MEMORANDUM

DATE: April 16, 2021

SUBJECT: Waterview North Sketch Plan Amendment
RE: Responses to CDOT Comments
PCD File No. SKP202.
LSC #204210

LSC Transportation Consultants, Inc. has prepared this memo in response to the February 5, 2021 Comment Letter prepared by CDOT – Region 2 – Permits.

Figure 13
Recommended Street Classification
Waterview North (LSC #204210)

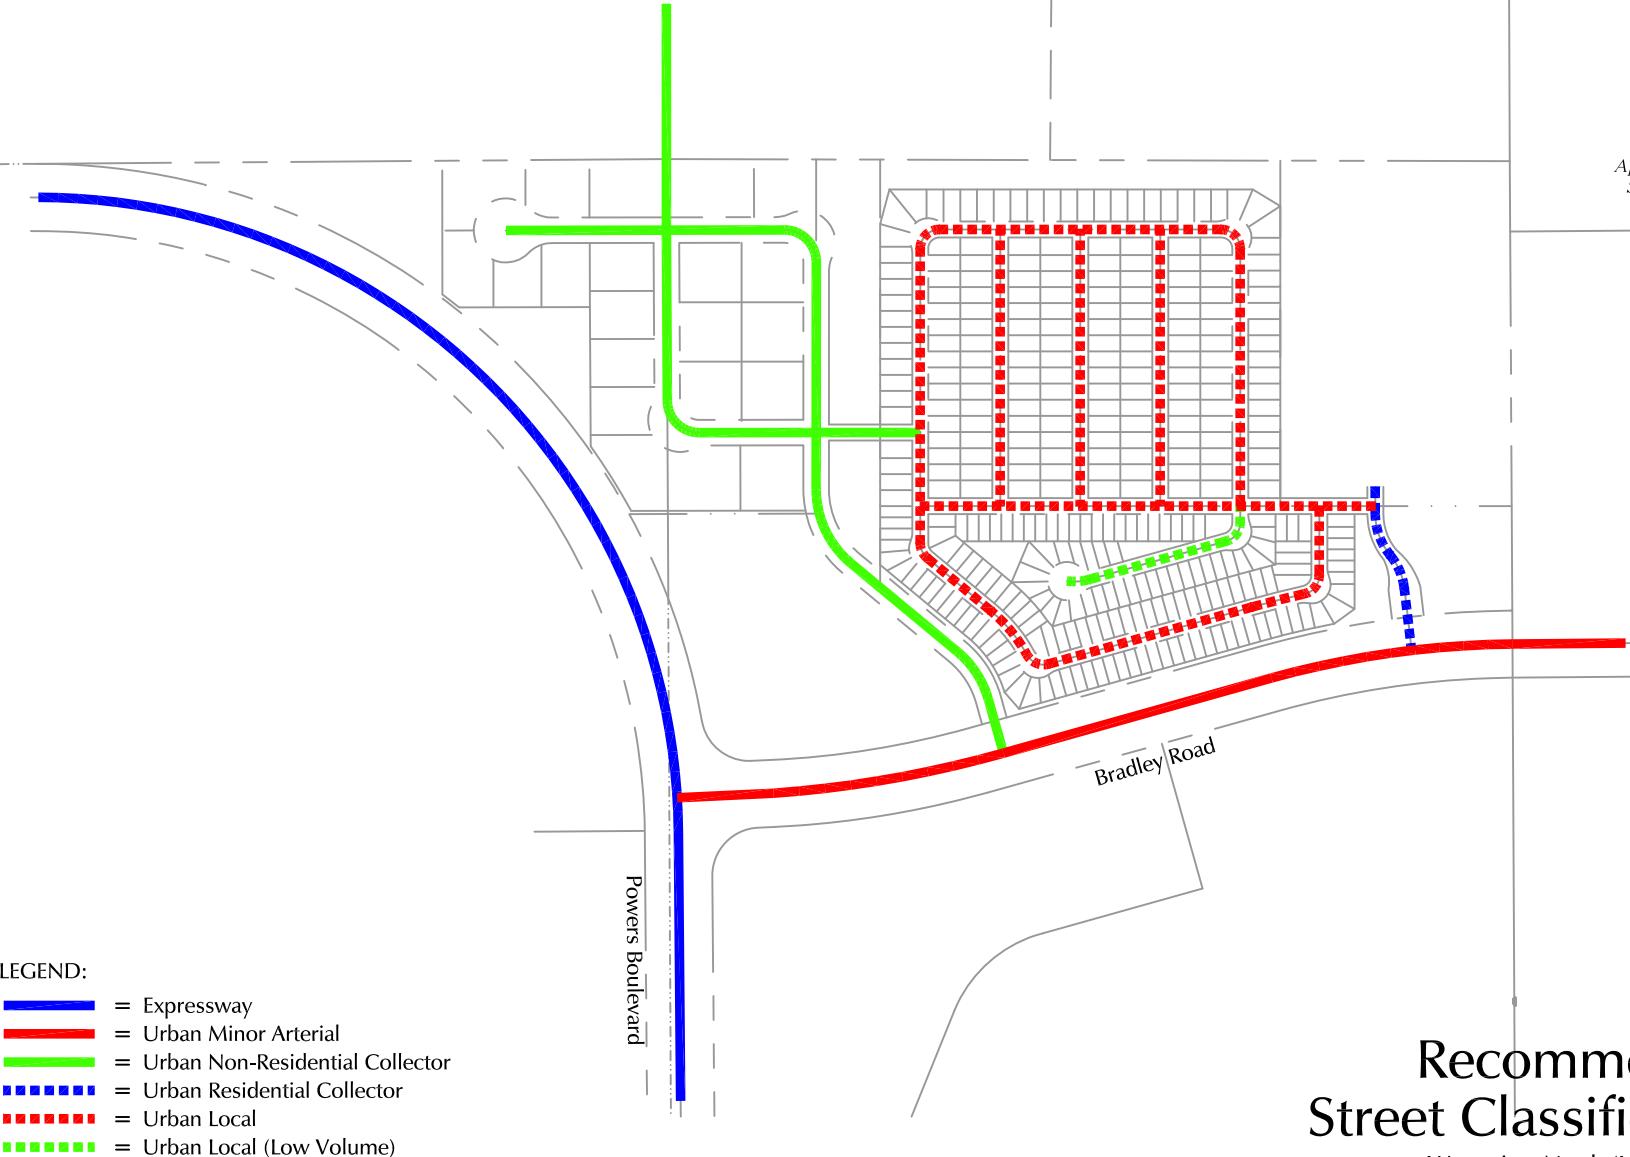
- g. The 2040 Synchro reports for Powers Blvd. Interchange Northbound Ramp at Bradley Rd is missing the existing left turn traffic in both time periods from Figure 13. Please update Figure 13.

This is an older comment that is not applicable to the Waterview North TIS. This comment applied to the TIS report for the Trails at Aspen Ridge (Springs East at Waterview) - PUDSP-191.

Figure 19 Long-Term Bradley Road Lane Recommendations figure from the *Springs at Waterview East Preliminary Plan Traffic Impact Study*

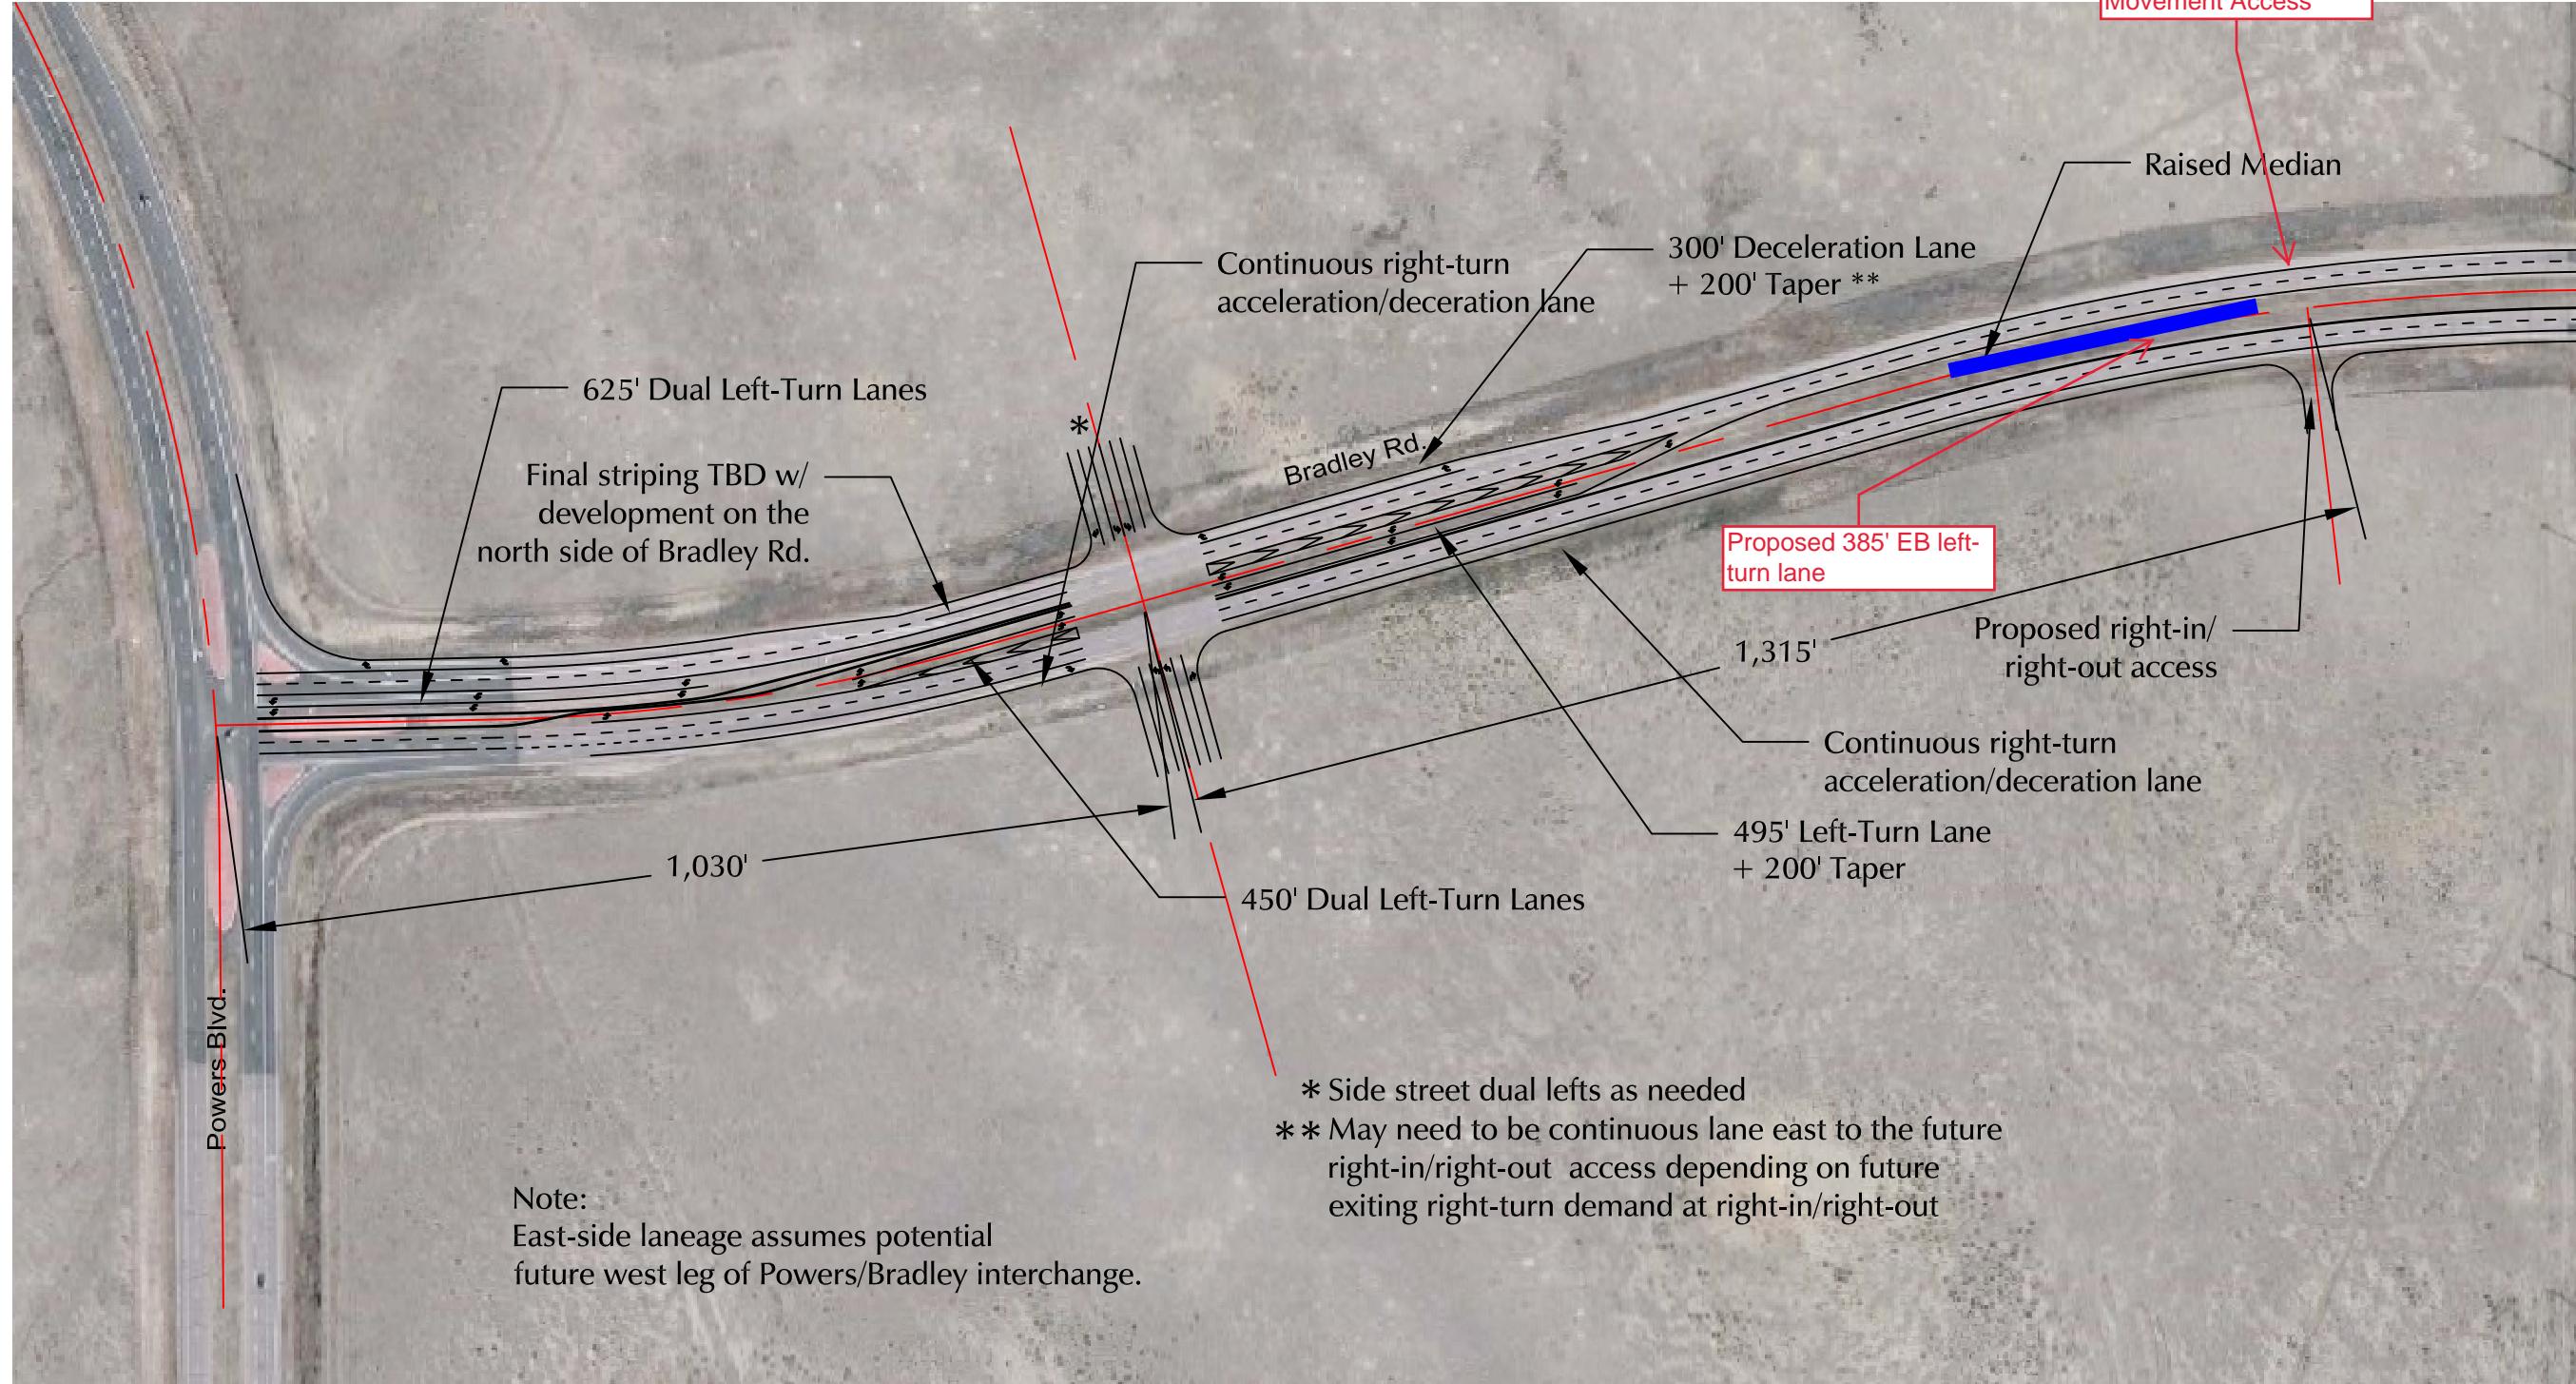
- h. The 2040 assumption of a six-lane Powers Blvd at Bradley overlooks the cost comparison of an interchange versus widening three miles of highway particularly with ADTs only at 40,000. The study should include an interchange alternative of 2040 traffic. Please update.  ¹
- i. Figure 19 depicts the long-term Bradley Road lane configuration east of Powers Blvd. It is clear from the drawing that the future eastbound left turn lanes for the future north side access will conflict with the future northbound ramp intersection. Please update.  ³
